Item No. **Report of the Head of Planning, Transportation and Regeneration**

Address BEAUFORT TILE KILN LANE HAREFIELD

Development: First floor rear extension and alterations to single storey rear roof from flat to pitched

LBH Ref Nos: **19064/APP/2018/2036**

rev:	date:	description:
scale:	1: 100	A1 date: 18 / 05 / 2018
drawing no:	1020 / P / 2	drawn: FJ
drawing:	PROPOSED FLOOR PLANS, ELEVATIONS, SITE PLAN & LOCATION PLAN	
project:	LAND AT BEAUFORT, TILE KILN LANE HAREFIELD, UXBRIDGE, UB9 6LU	
client:	MR & MRS JARIWALA

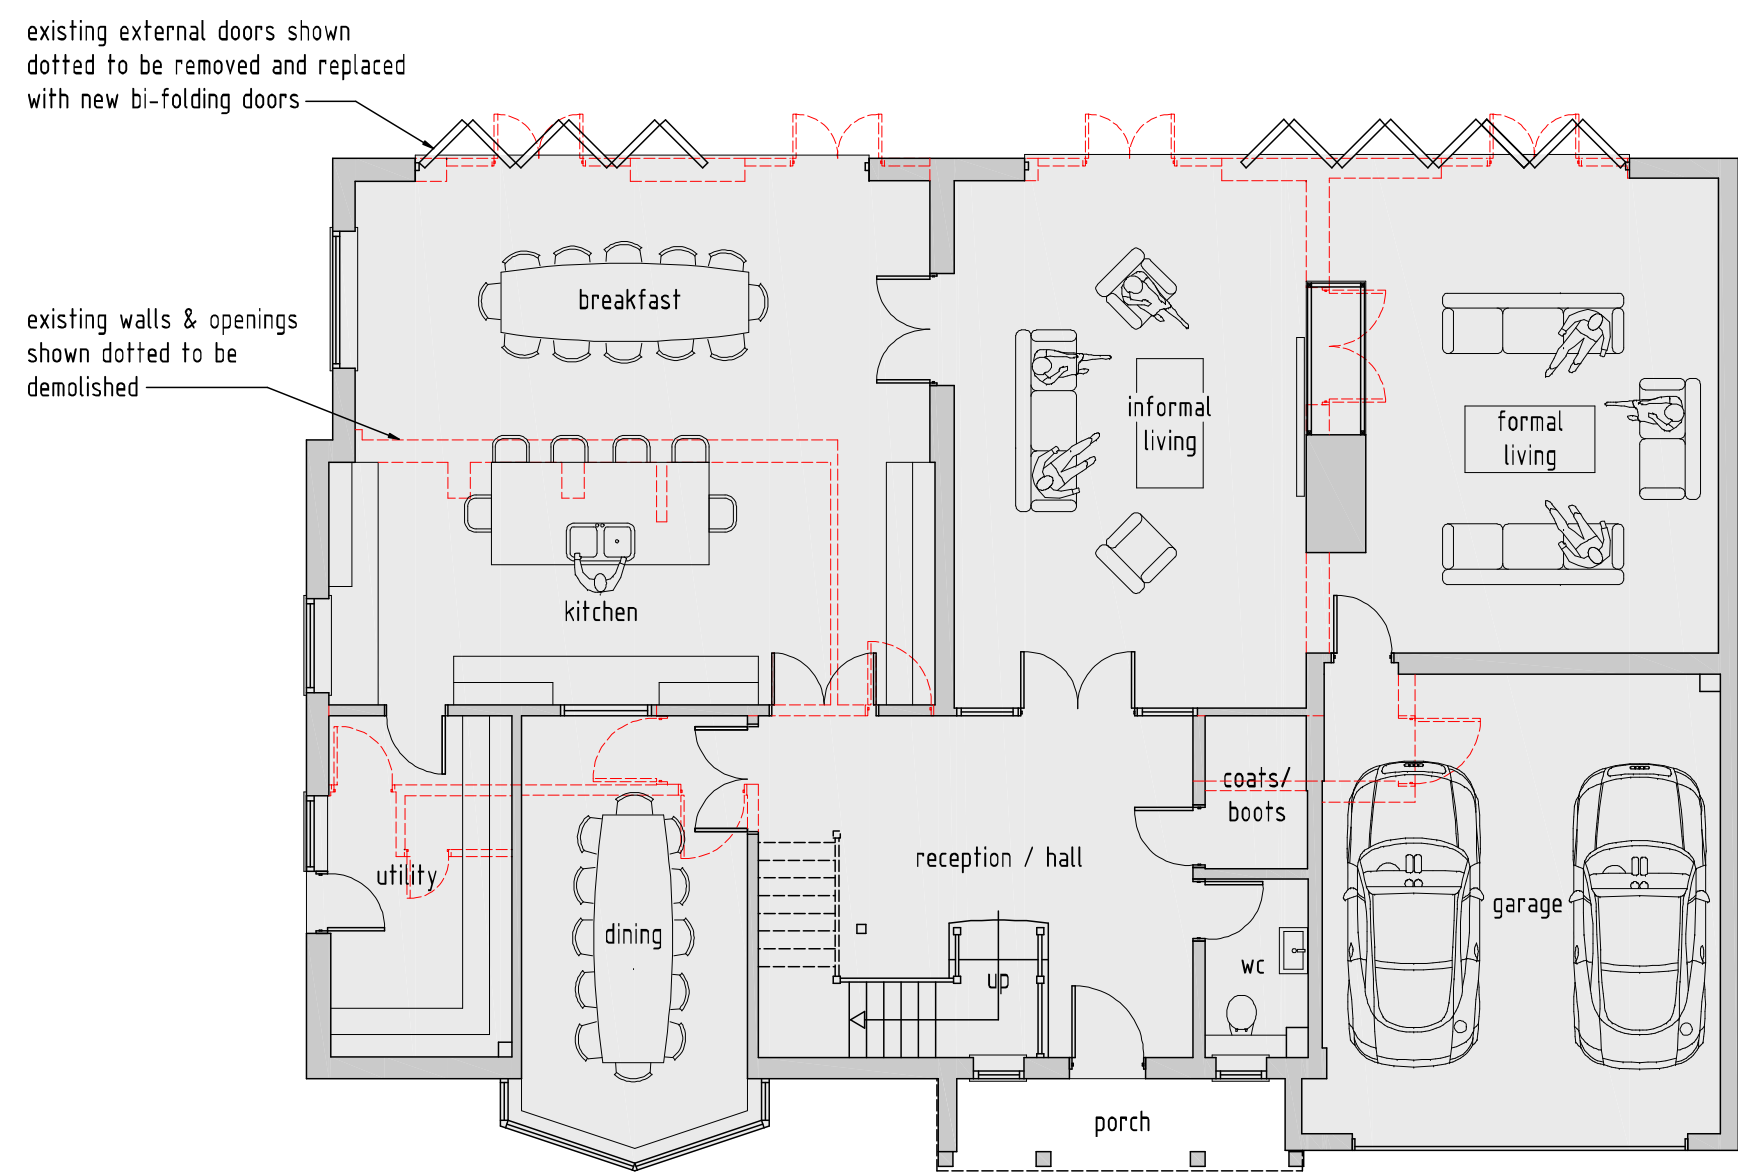
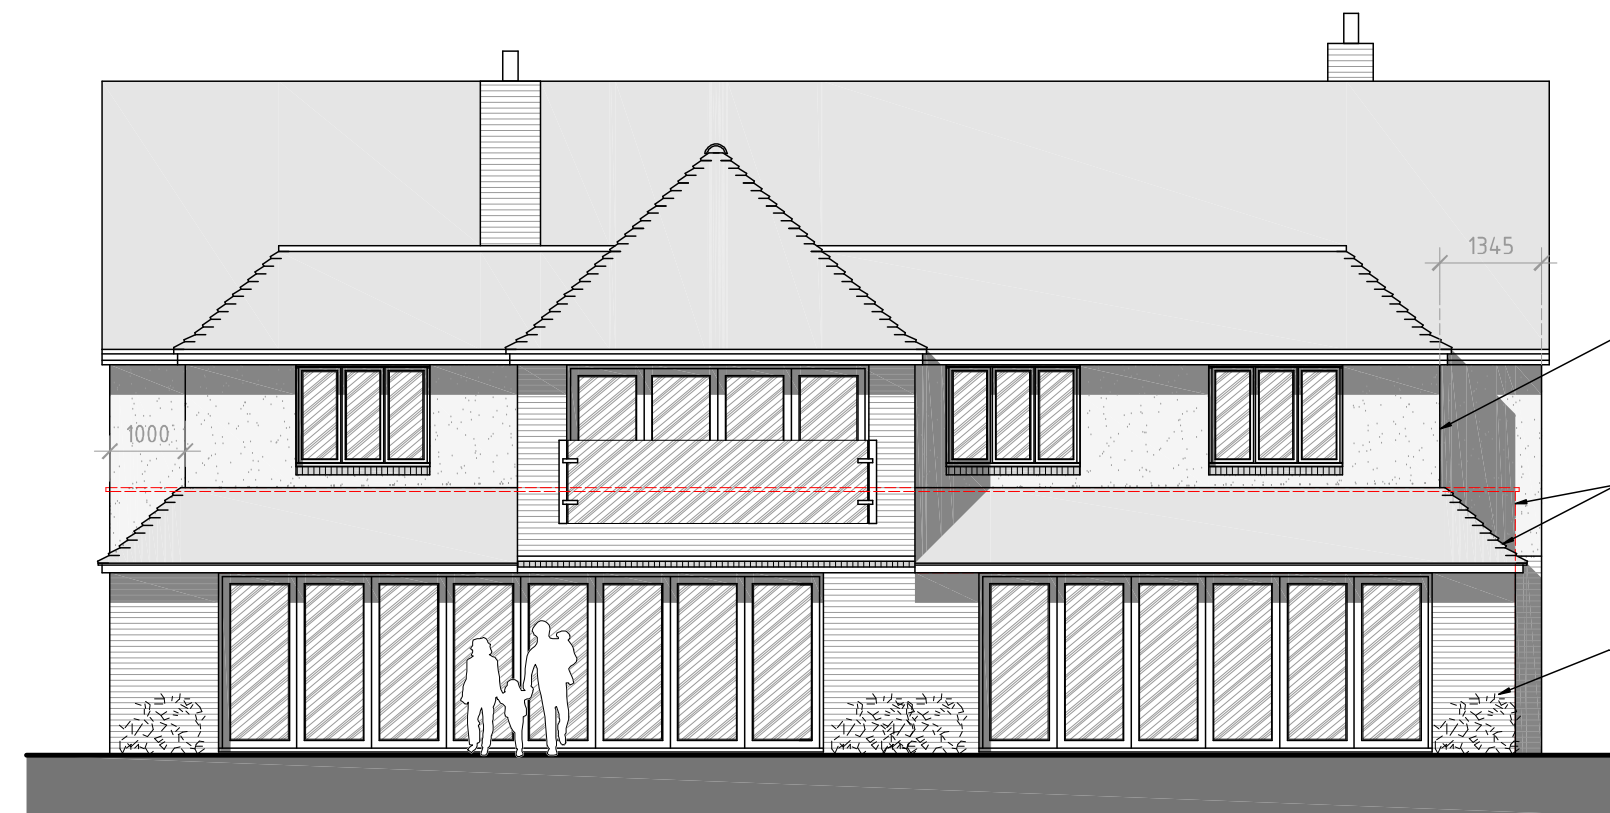
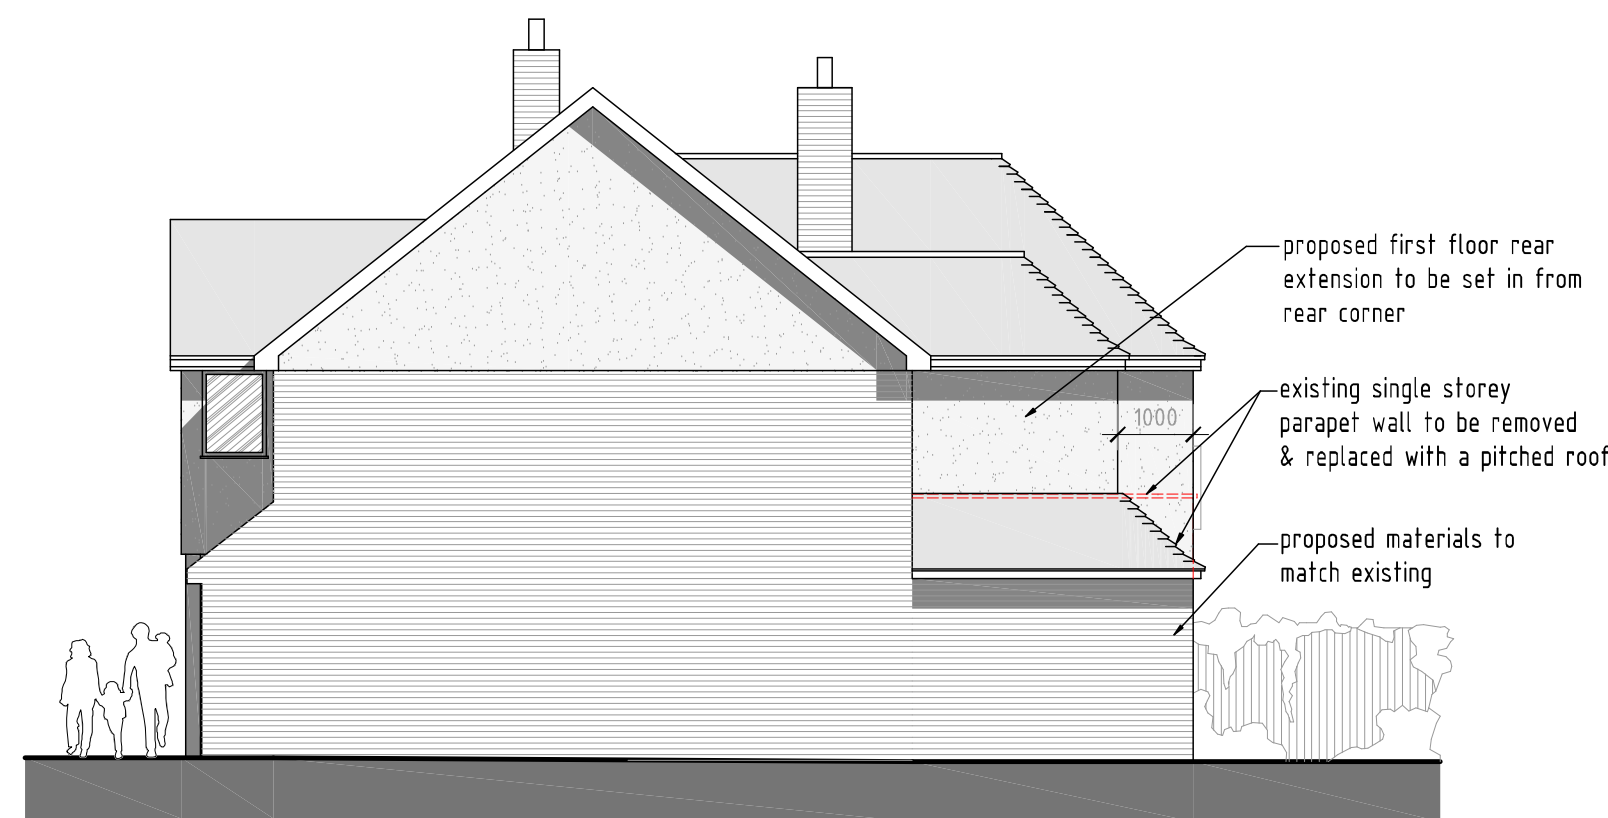
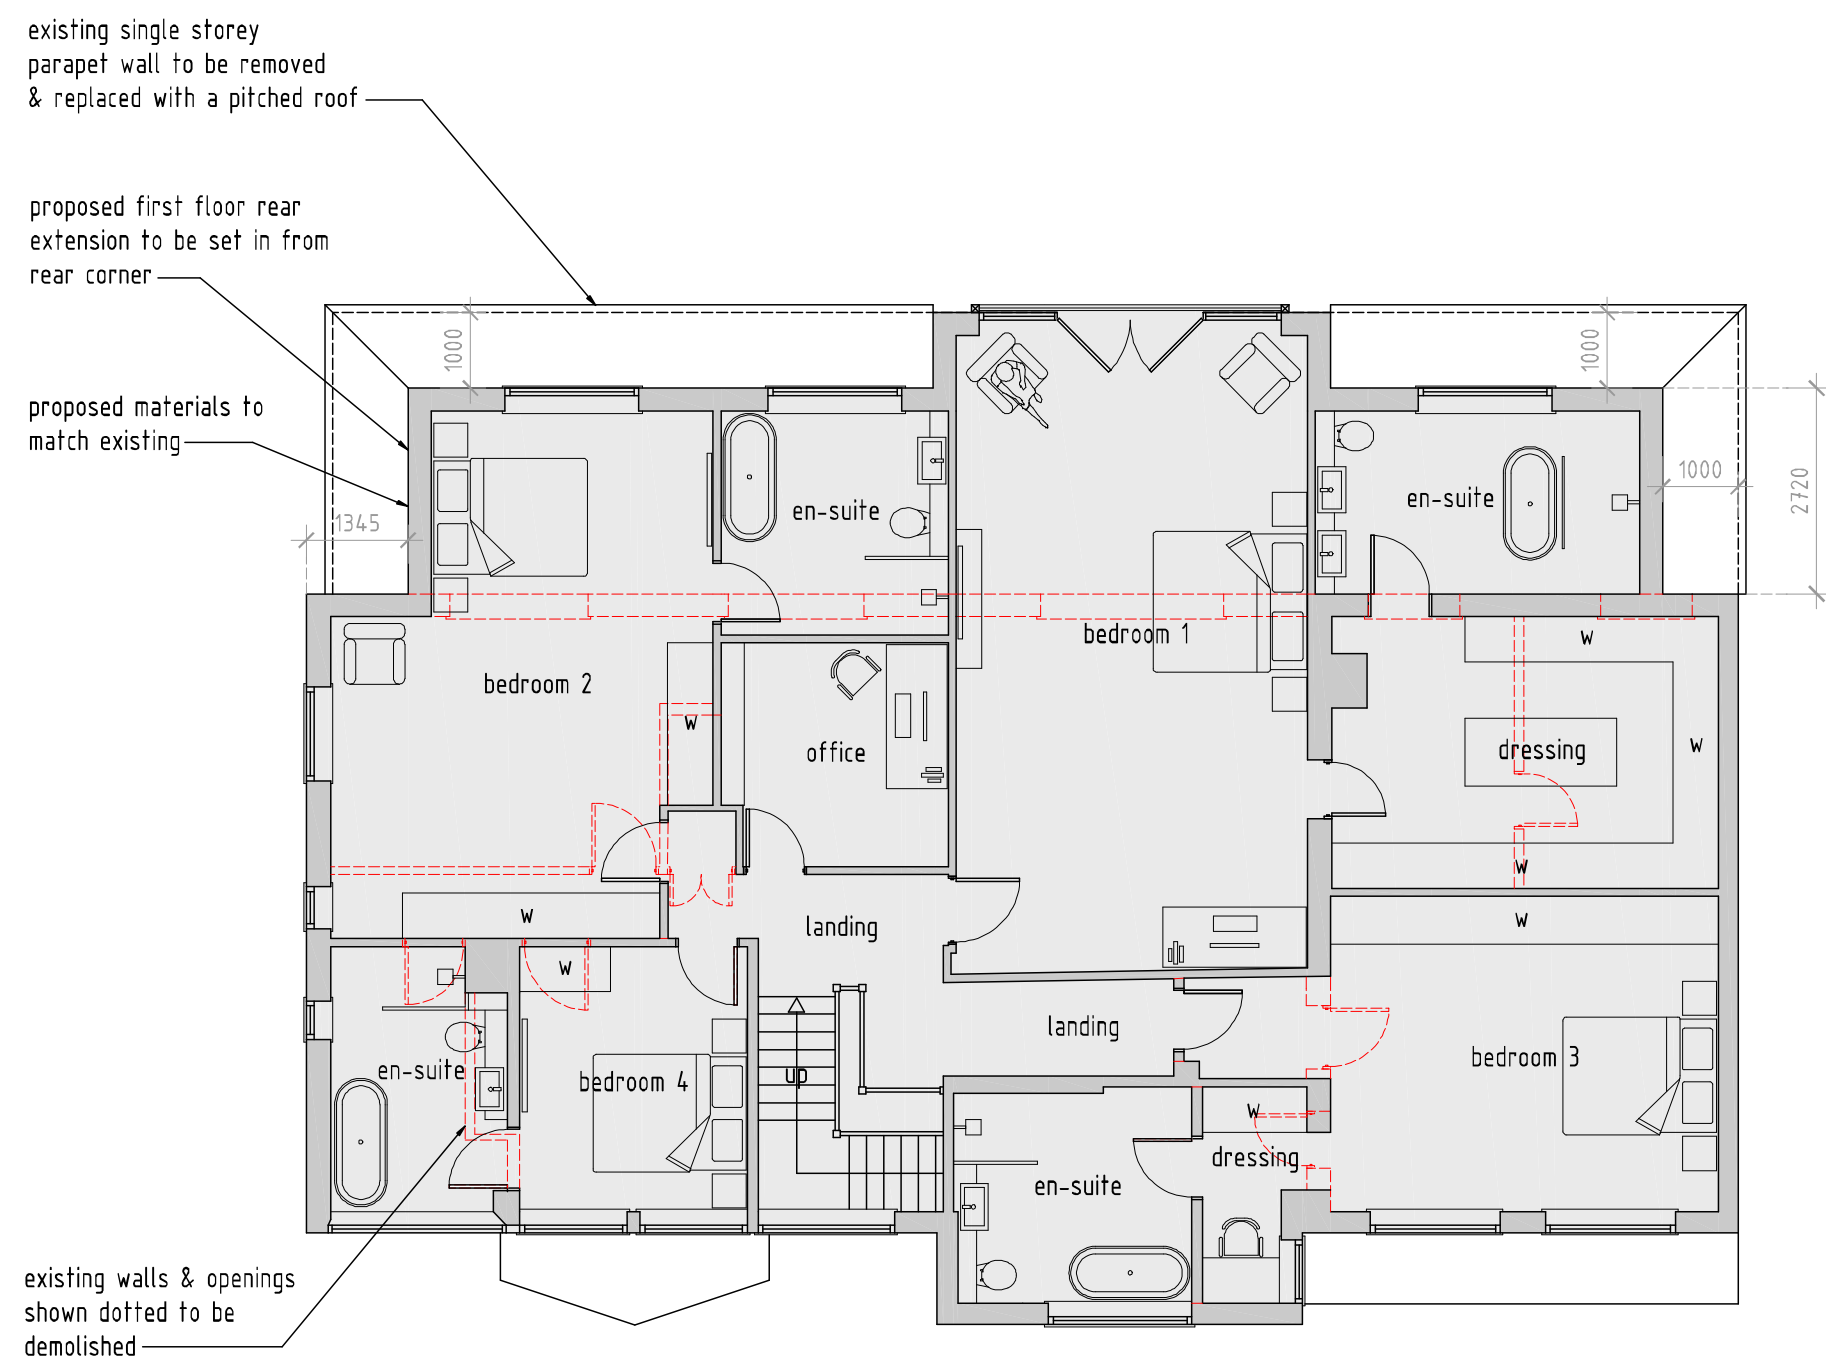
The proposed first floor side/rear extension would wrap across the rear wall of the existing house and would be 2.7 and 3.7 m deep and 16.6 m wide. The proposal would be characterised by one feature gable with one hipped roof which is almost central to the rear elevation measuring a maximum height of 8.05 m which would have a ridge height by approximately 0.86 m lower than the original roof which complies with the ridge height for first floor side/rear extensions, as specified in paragraph 5.8 and 6.6 of the HDAS SPD. The HDAS states extensions to detached dwellings up to a maximum of 4 m deep would be acceptable. The proposed first floor side extension would have a width of 4.4 m, which is between half and two-thirds of the original house width (13.58 m) so it complies with paragraph 5.10 of the HDAS SPD.

Furthermore, the proposed roof profile should match that of the existing roof. This would not be possible as the property would have a feature gable with one hipped roof and a very large crown/almost flat roof profile, which is a consequence of the fact that it is too wide, and thus would result in an extension which would be a considerable change to the character and appearance of the existing property and which fails to be subordinate to the original property. This results in an unbalanced appearance between the other dwellings in wider area and would impact unduly on the character and appearance of the existing and adjoining properties and the visual amenities of the street scene and the area in general.

As such, the proposed extension does not appear subordinate to the main dwelling by

virtue of its size, scale roof design and would not harmonise with the existing dwelling, and it is considered that it would not be in keeping with the architectural integrity of the dwelling and the character and appearance of the surrounding area, thereby the proposal would not comply with the requirements of Policy BE1 of the Hillingdon Local Plan: Part One - Strategic Policies (November 2012), Policies BE13, BE15 and BE19 and OL4 of the Hillingdon Local Plan: Part Two - Saved UDP Policies (November 2012) and the HDAS SPD: Residential Extensions (December 2008) and NPPF.

The proposed development, by reason of its overall size, bulk and scale, in conjunction with previous substantial extensions, would represent a disproportionate change in the bulk and character of the original building and therefore would significantly increase the built up appearance of the site and would be visually intrusive within the street scene and the wider area. The proposal would therefore constitute inappropriate development in the Green Belt, contrary to Policies OL1, OL4, BE13, BE15 and BE19 of the Hillingdon Local Plan: Part Two - Saved UDP Policies (November 2012), Policy 7.16 of the London Plan and the National Planning Policy Framework.

The proposed first floor side/rear extension, by reason of its size, scale, bulk and design would constitute an overdevelopment of the plot, resulting in incongruous and unsympathetic additions to the original dwelling which would subsume and engulf its character to the detriment of the architectural composition of the original dwelling and to the visual amenities of the street scene and the surrounding area. Therefore the proposal would be contrary to Policy BE1 of the Hillingdon Local Plan: Part One - Strategic Policies (November 2012), Policies BE13, BE15 and BE19 of the Hillingdon Local Plan: Part Two - Unitary Development Plan Saved Policies (November 2012) and the adopted Supplementary Planning Document HDAS: Residential Extensions.
